AB/12/21/PL

Old Bank House 3 High Street Arundel BN18 9AD

Internal & external alterations to existing building to facilitate the change of use to a residential dwelling granted under AB/122/20/PD to include demolition of single storey rear extension, removal of rear external chimney, change existing window to front elevation to entrance door & new french doors to rear elevation. This application affects the setting of a listed building, affects the character & appearance of the Arundel Conservation area & is in CIL Zone 2 (Zero Rated) as other development.

Project:-			
Old Bank House 3 High Street Arundel West Sussex			
Title:-			
Proposed Site Plan			
Client:-			
Moor Construction Ltd			
Scale:-			
1:100 (@A1)			
Drawn By:-	PJD	Checked By:-	PJD
Date:-	12/02/21	Date:-	12/02/21
Job.No:-	200042	Drg.No:-	22
		Rev:-	A

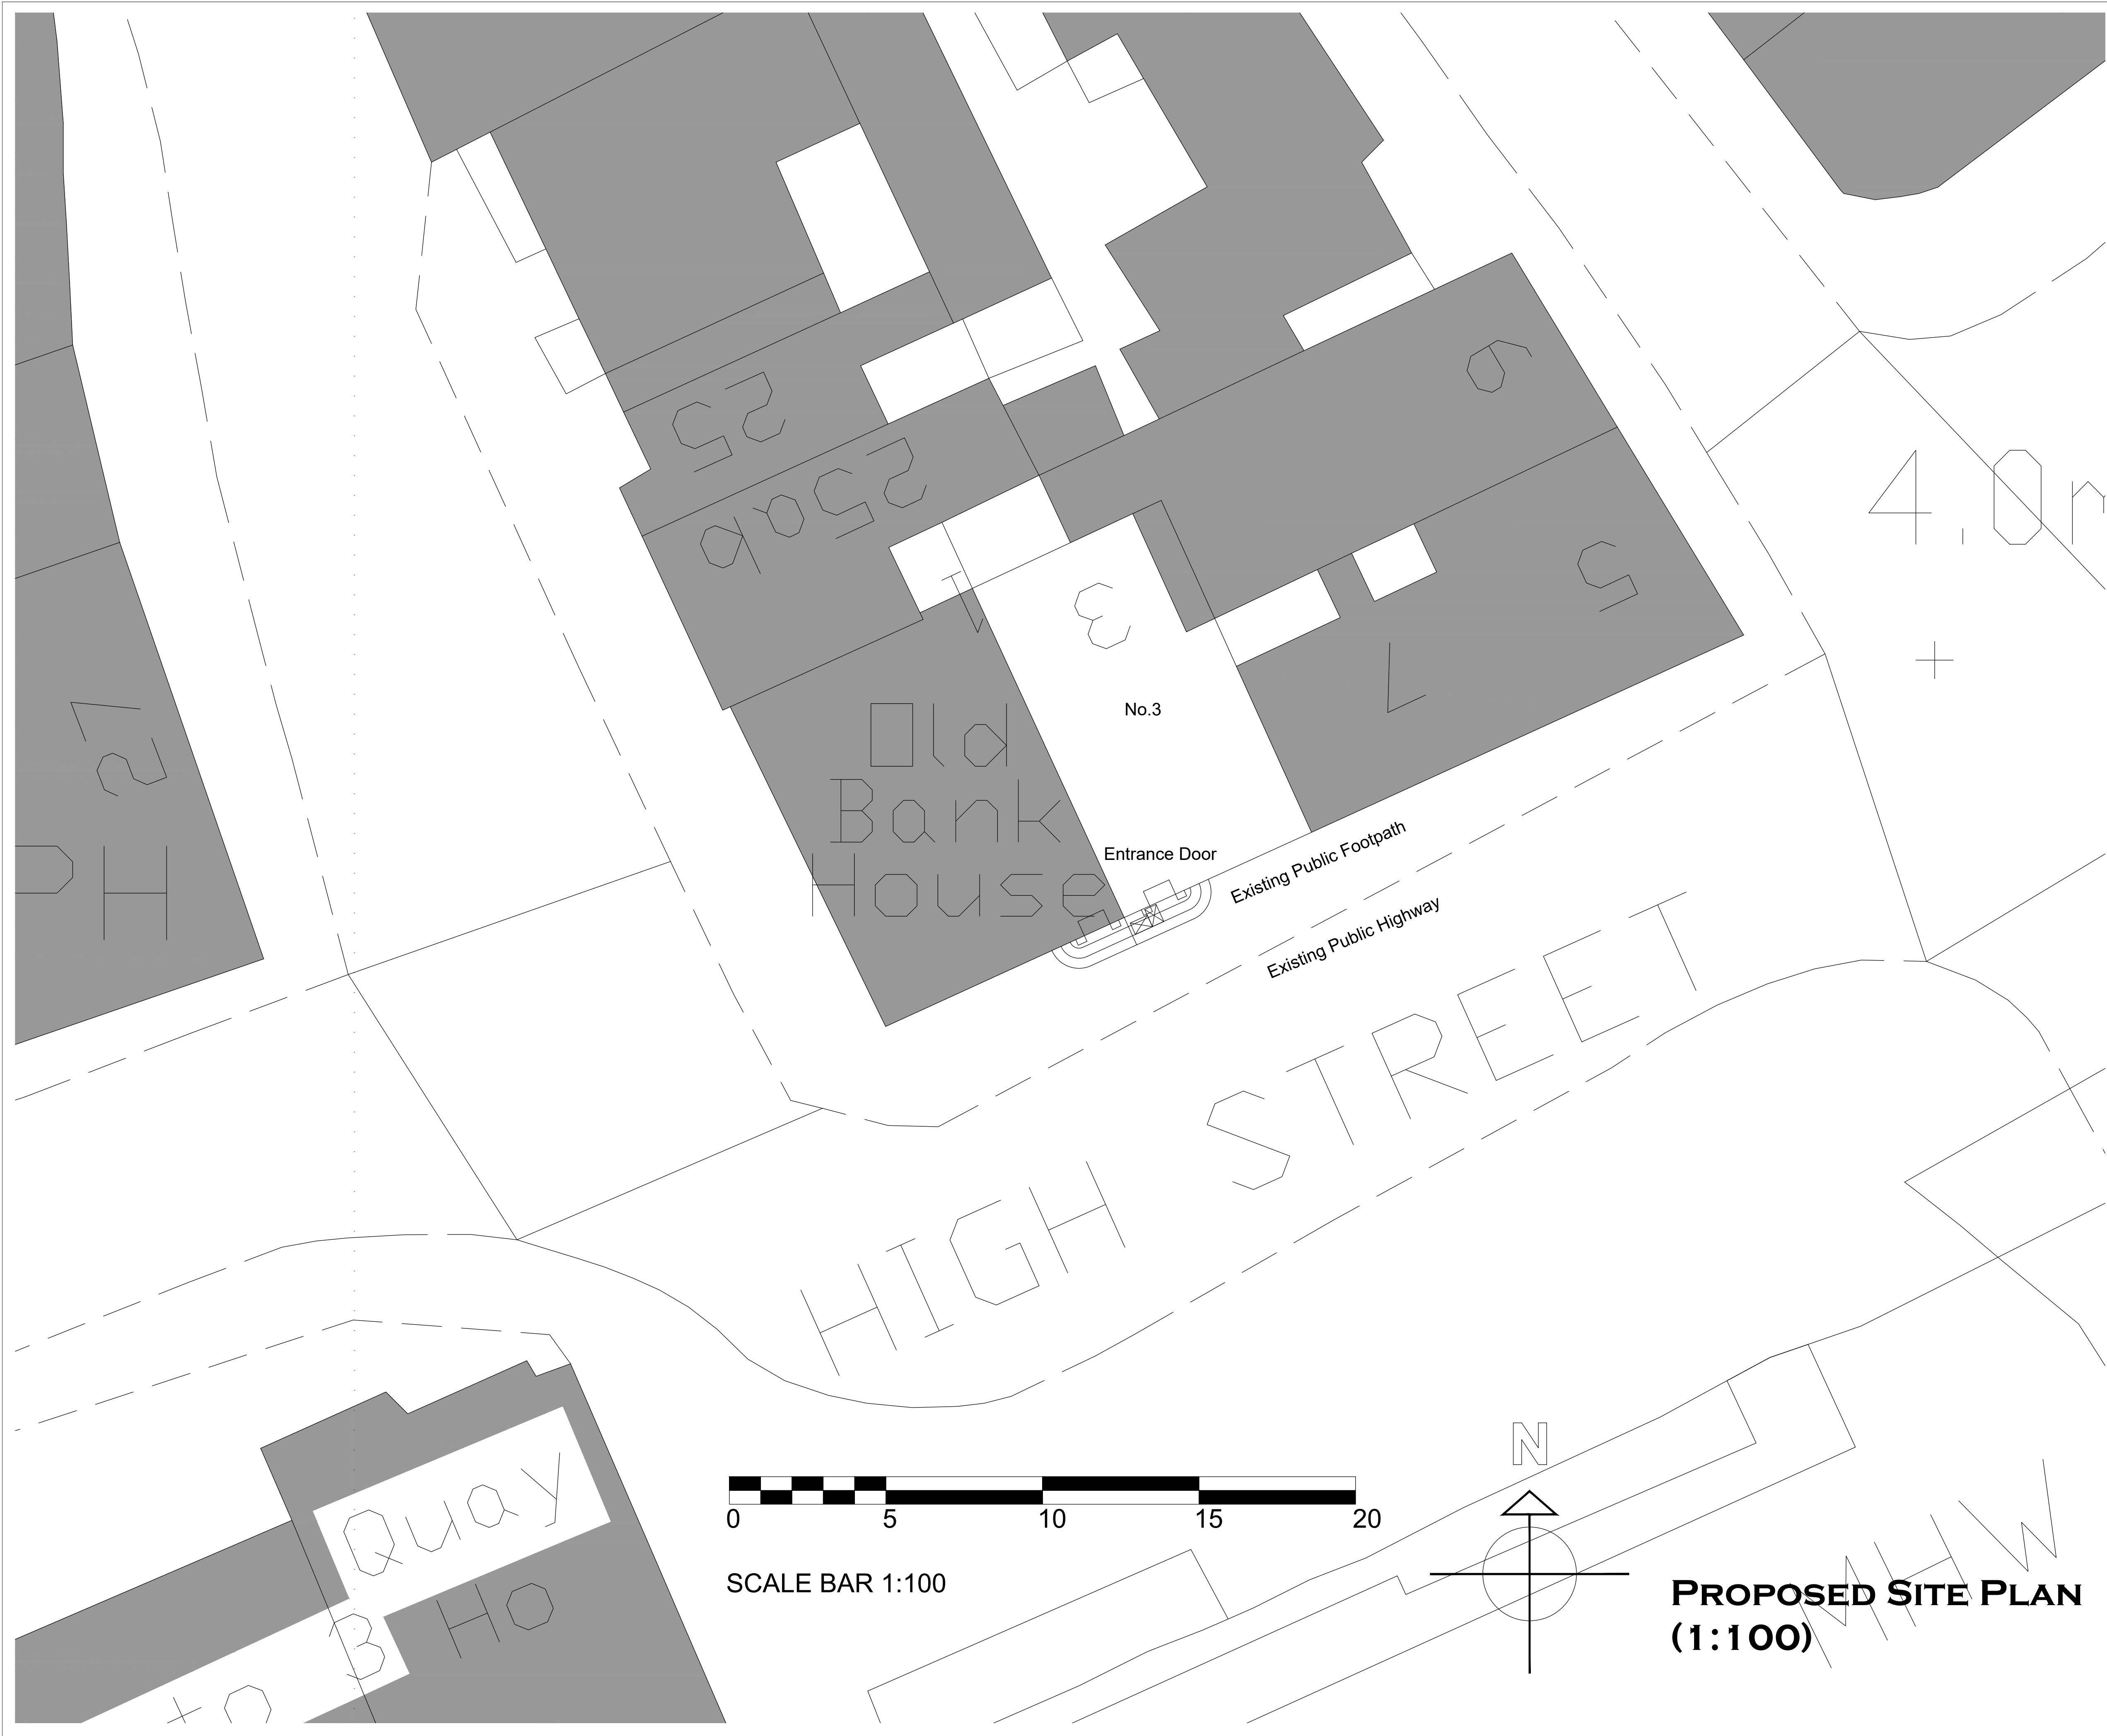
Based on the elevation drawings it would appear that the proposed replacement entrance door would attempt to reflect that of the neighbouring listed building. However, there are issues with the current proposal. The ground floor plans show the new front door being almost flush with the front wall, as opposed to being deeply recessed as seen in the neighbouring listed building. In order for this element of the proposal to be positive and acceptable, the new door and opening should closely reflect the existing version. I also note that only the elevation indicates the presence of the steps from the street level, and that it is missing from the floor plans.

### Proposed Step Details

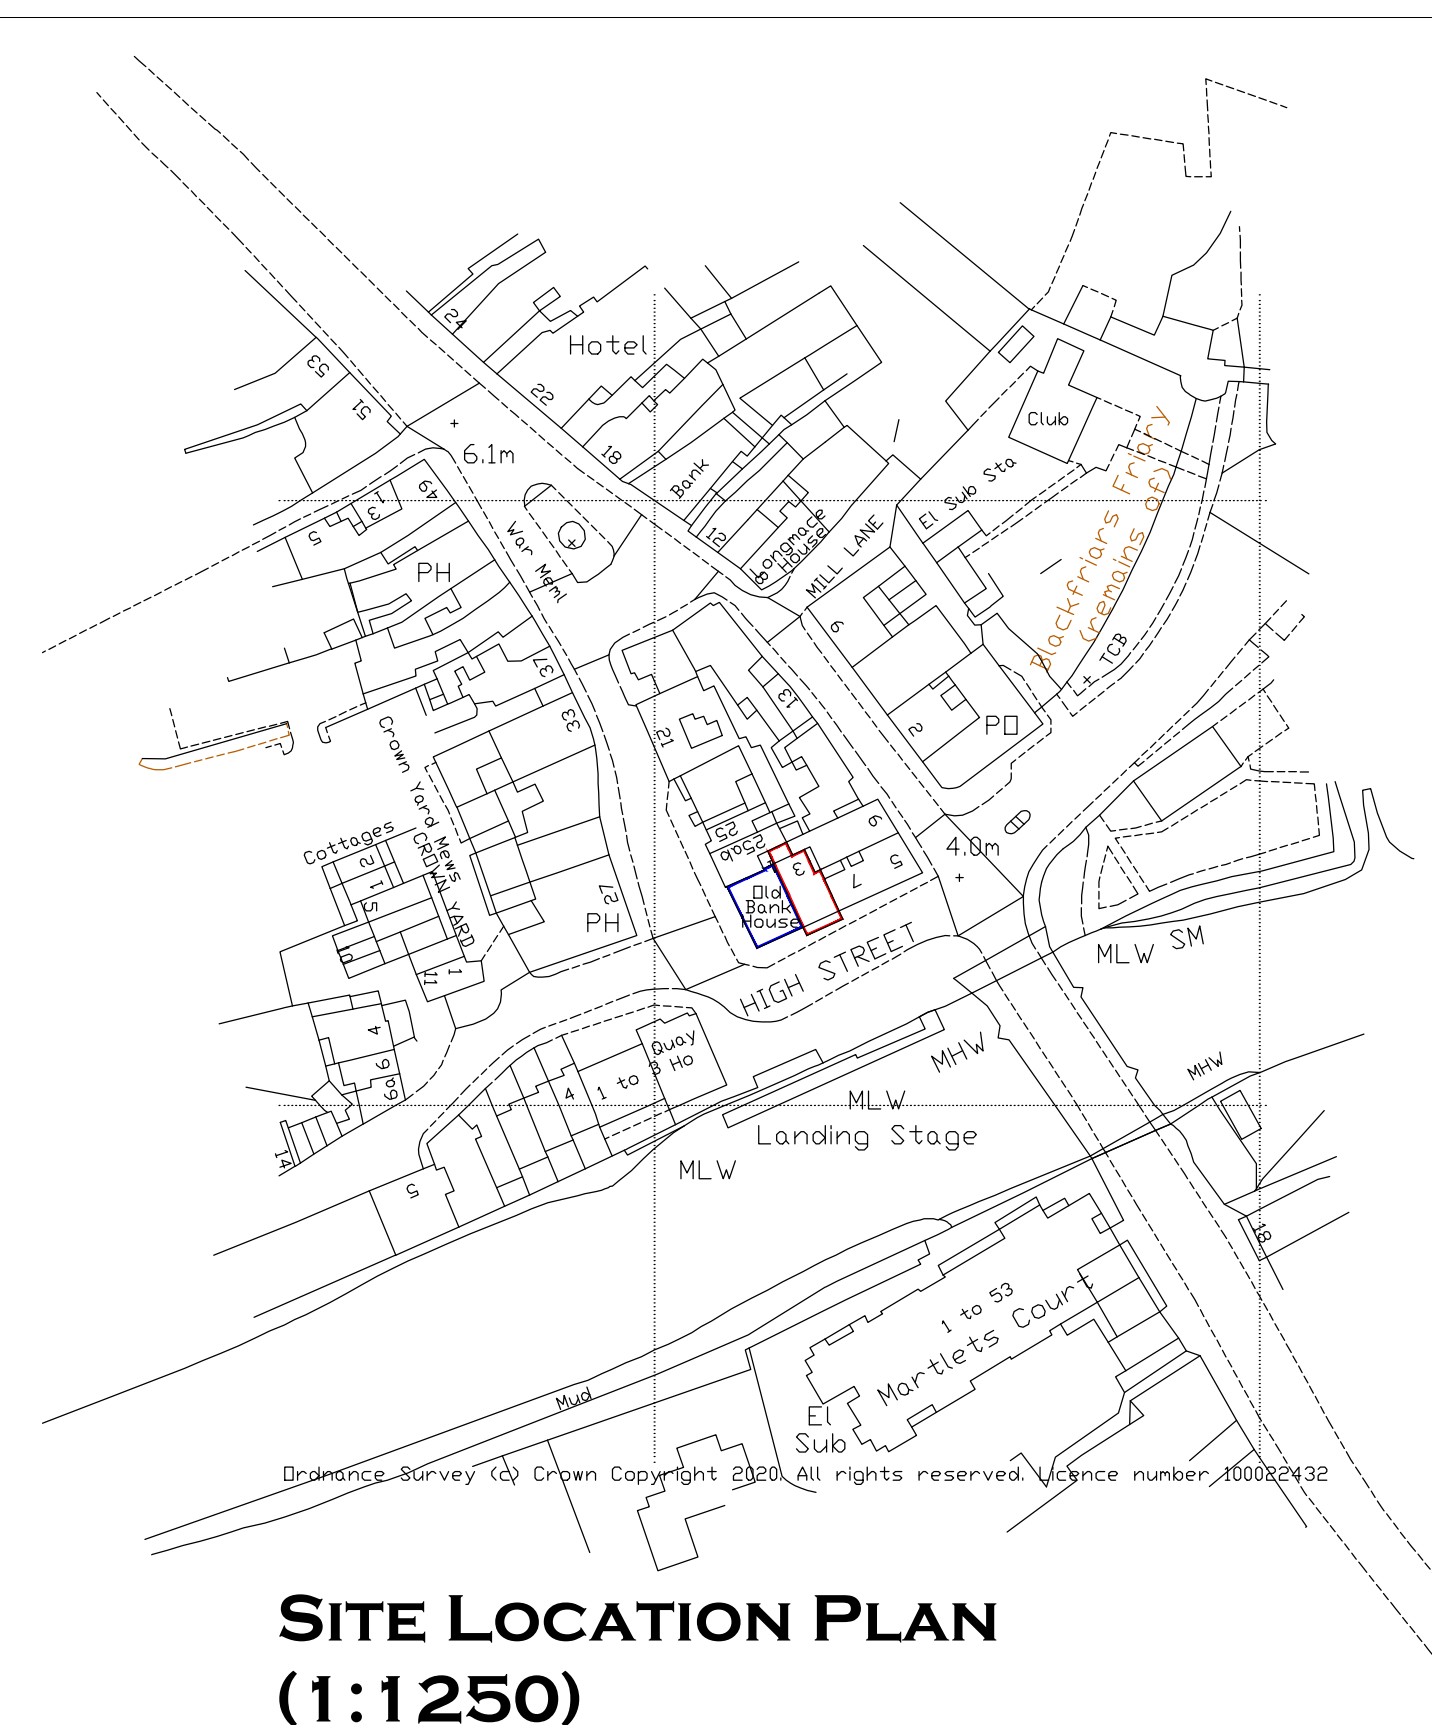
The new steps are required to accurately reflect those of their neighbour in terms of materials and appearance. At present, it is not clear what these would be constructed from alternative ones such as a trowelled cement finish.

Based on the level of information provided it is difficult to fully understand the proposals and assess their impact. It would help to have greater level of information so as to ensure that the new doors and steps reflect the existing ones. As a consequence, details of the new door and entrance should incorporate a painted timber doorcase which precisely matches in design, dimensions, profile and detailing that of the adjacent listed building. Detailed plans (to an appropriate scale) should be provided of both the door/doorcase and steps, and schedules of materials should ideally accompany the application, or be provided by way of condition if you are minded to approve the application. Details of the proposed paint colour should also be provided.

Whilst the concept of replicating the details of the neighbouring property is acceptable, the level of detail in the application is not enough to fully understand what the door/doorcase and steps would look like.
